Phone: 0300 123 6780
Email: Kathryn.Walsh@lancashire.gov.uk
Your ref: 3/2025/0081
Our ref: 3/2025/0081/HDC/KW
Date: 14 March 2025

Location: Land adj to 110 Ribchester Road Clayton le Dale BB1 9HQ
Proposal: Reserved matters application relating to appearance, landscaping, layout, scale following outline planning permission 3/2022/0632 for one self-build dwelling with access applied for.
Grid Ref: 367729 433017

PROPOSED GROUND FLOOR PLAN
Scale 1:50

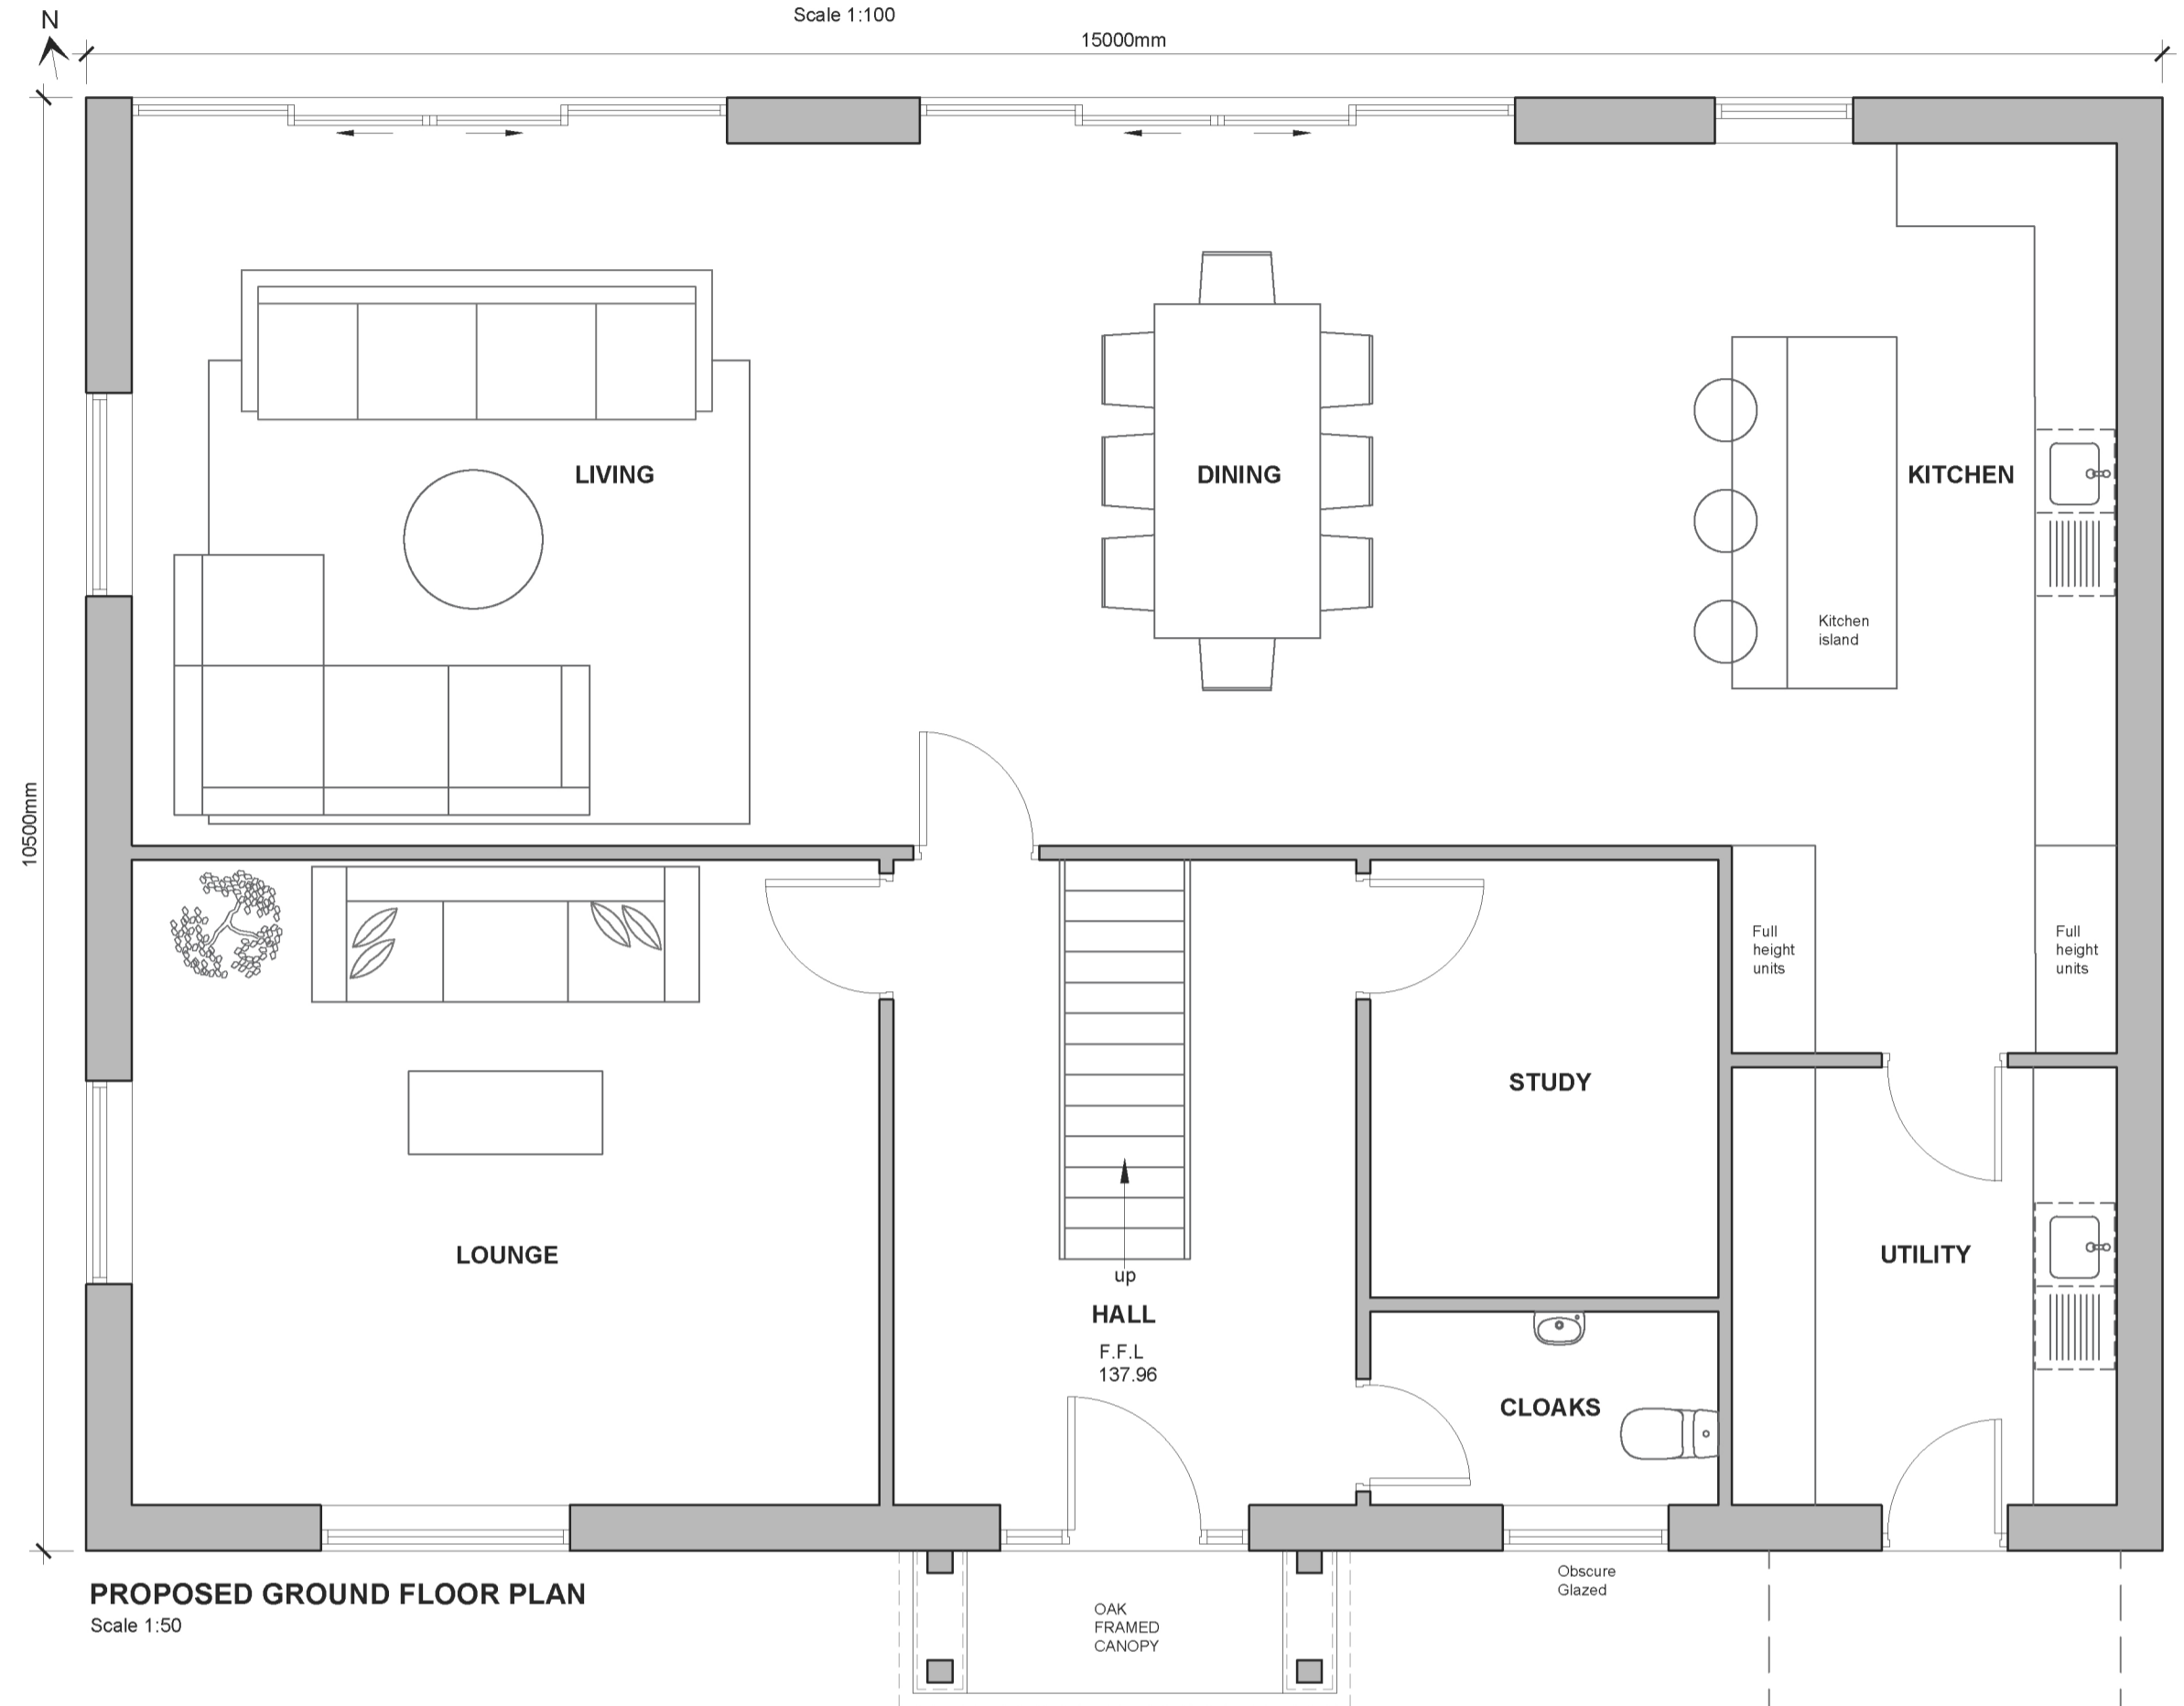
The recommended minimum internal dimensions for a single garage size is 6m in length and 3m wide. The recommended distance of 6m is based on the length of a large family car (Ford Mondeo Estate 4.58m long), clearance at the rear of the car (200mm), overhang of the garage door (600mm) and room to stand in front of the car and open/close the garage door (600mm). The LHA has reviewed the proposed floor, drawing 2338-01 Rev B and note that the garage have been designed to an acceptable internal size to provide parking.
